From: Amanda Scholes on behalf of Planning.Responses
Sent: 26 February 2020 12:32
To: Planning Scanning
Subject: FW: Nyton Stables, Arun Ref AL/60/19/DOC

From: Simon Davis
Sent: 26 February 2020 12:10
To: Planning.Responses
Subject: Nyton Stables, Arun Ref AL/60/19/DOC

From: Rachel Alderson
Sent: 26 February 2020 10:53
To: Simon Davis
Cc: Rosemarie Dannatt
Subject: RE: Nyton Stables, Arun Ref AL/60/19/DOC

Are we also able to discharge Condition 08 *"Within 3 months of the date of this planning permission, a landscape management plan, including management and maintenance schedules for all new planting, shall be submitted to and approved in writing by the Local Planning Authority. The landscape management plan shall thereafter be carried out as approved."* on the basis of the Landscape Management & Maintenance Statement from (July 2019) or will that need updating too?

DRAWING NO: 18307-2-103 RevG

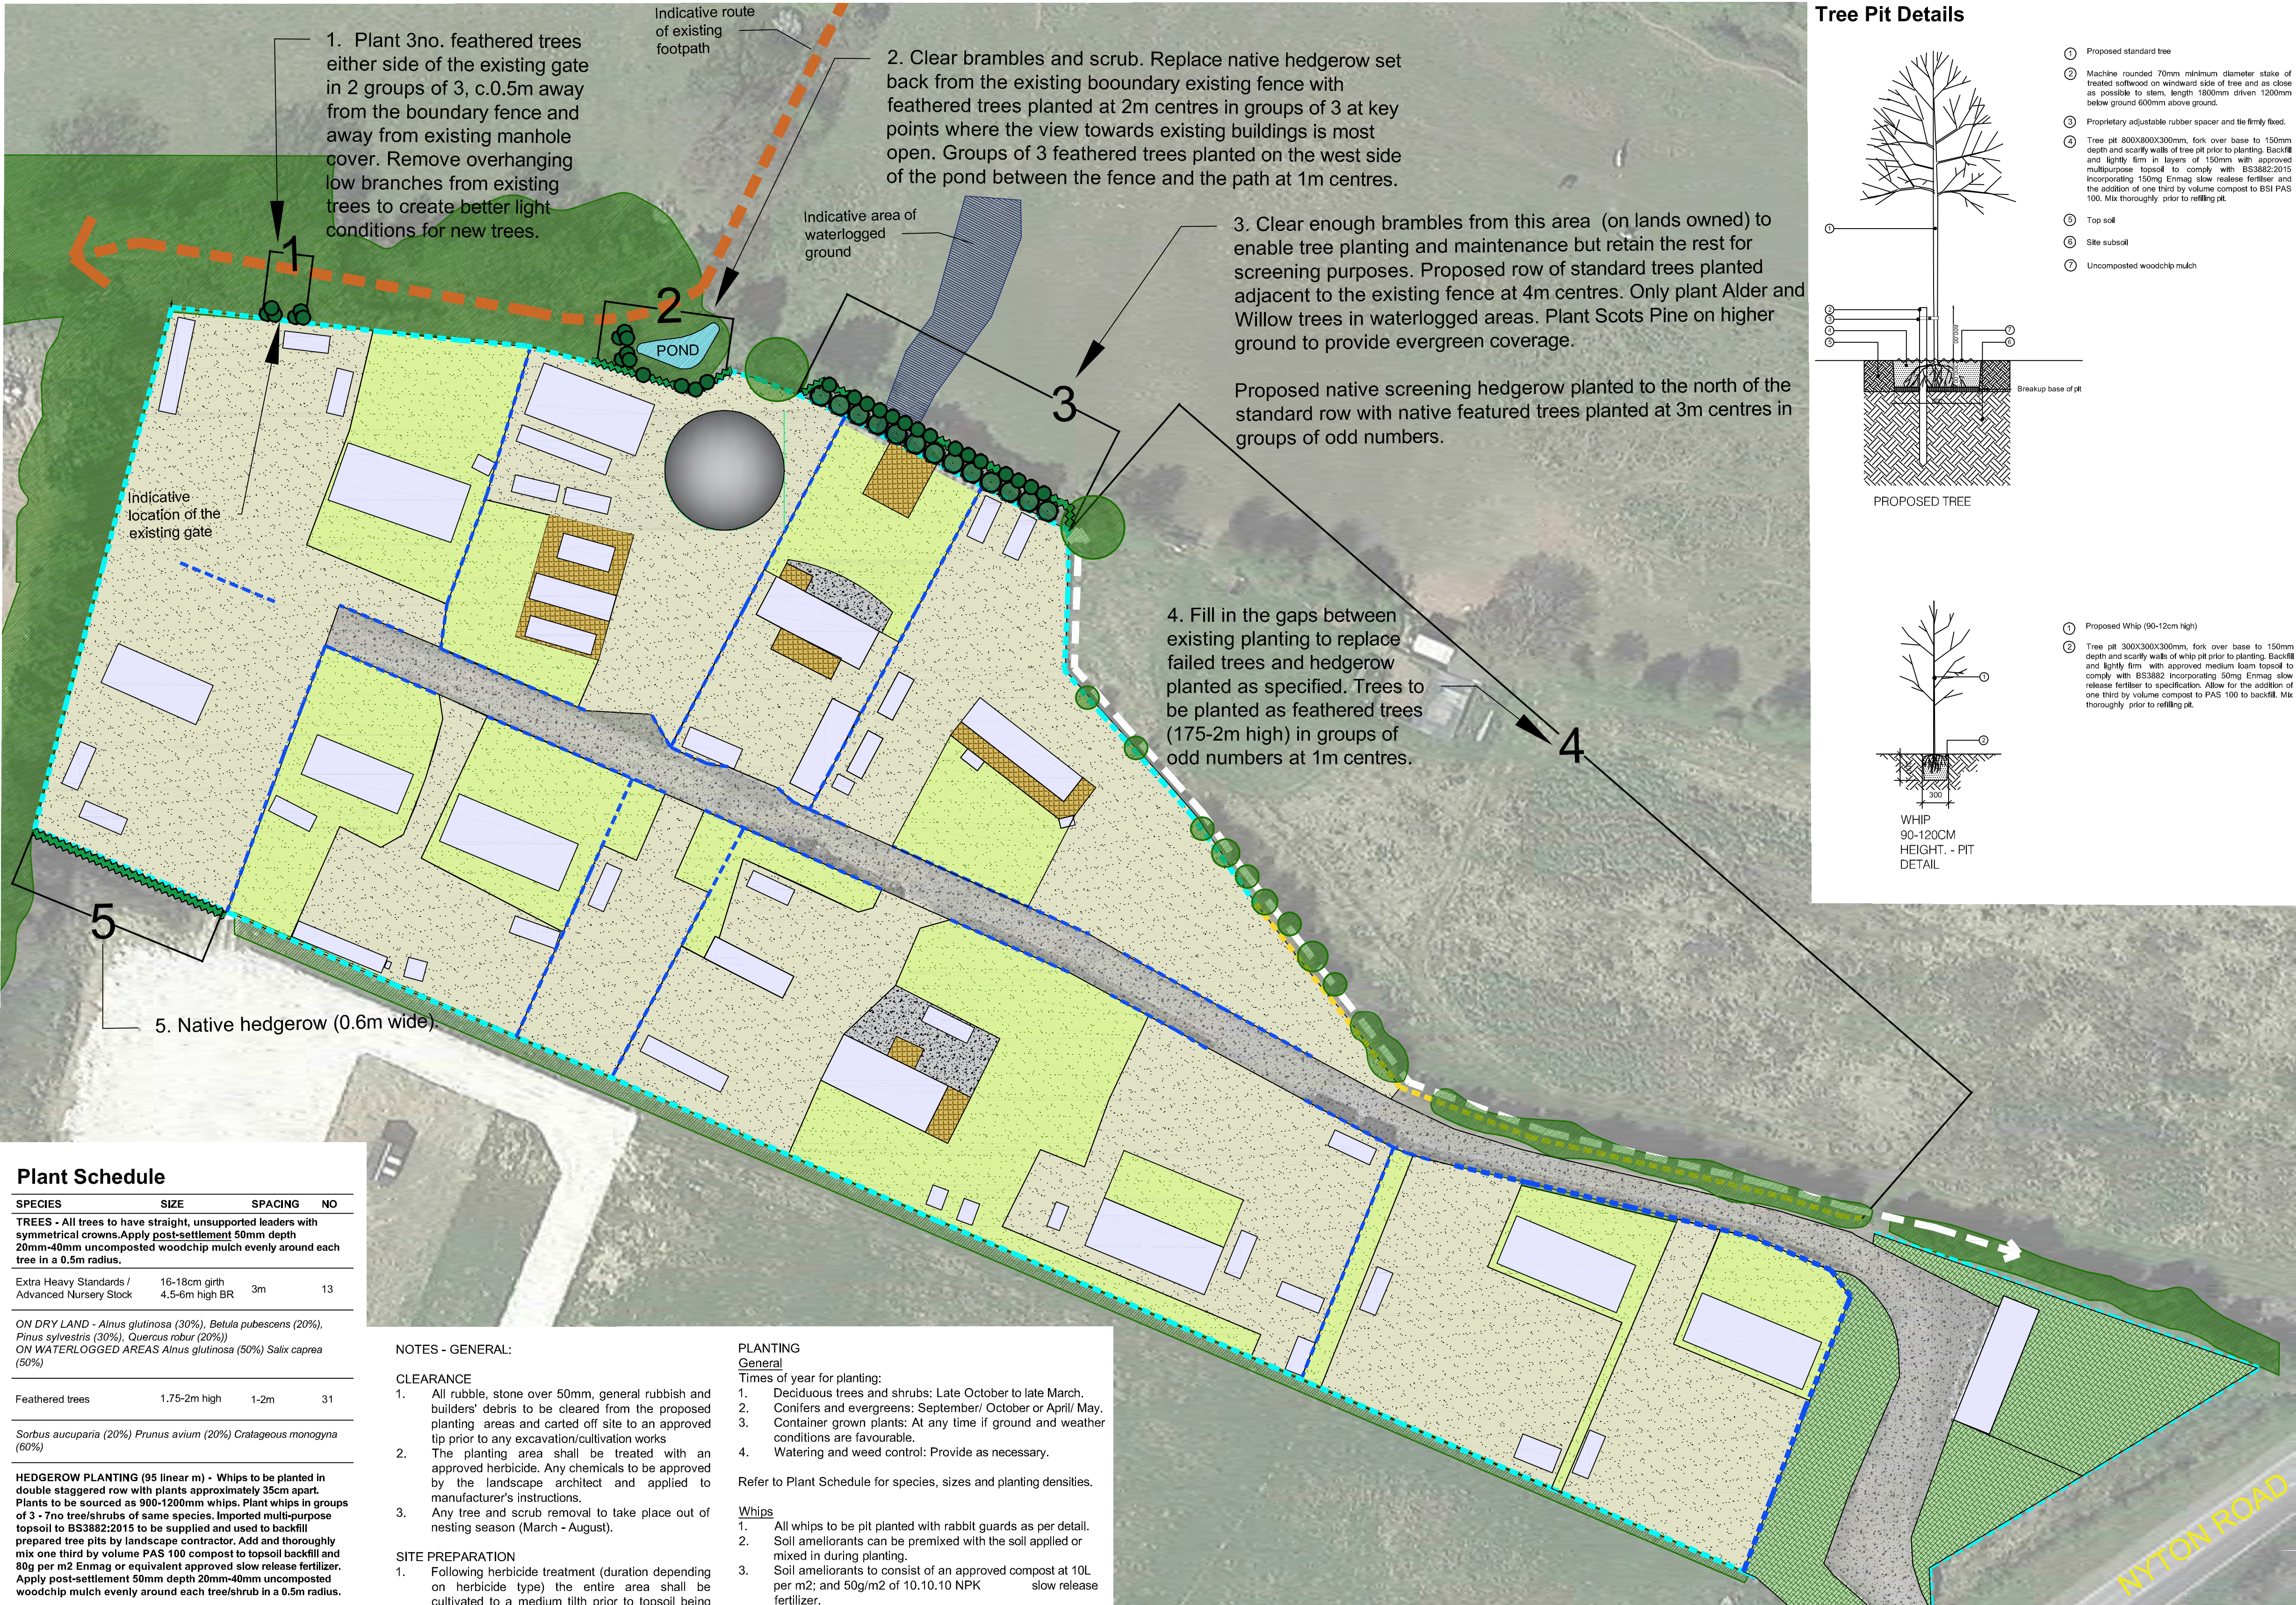
The only thing missing from the 'Landscape Management & Maintenance Statement' (July 2019) is the need to attach a rabbit guard to all new trees. The maintenance of guards is referenced in 2.7 but it is essential that the trees are protected from rabbits. Previous trees planted did/do have the guards so I would assume it will be the same this time.

I am therefore happy to agree to the discharge of the condition as long it is confirmed rabbit guards will be used. Do we need a revised document to confirm this as I don't want to hold up the applicant progressing the planting.
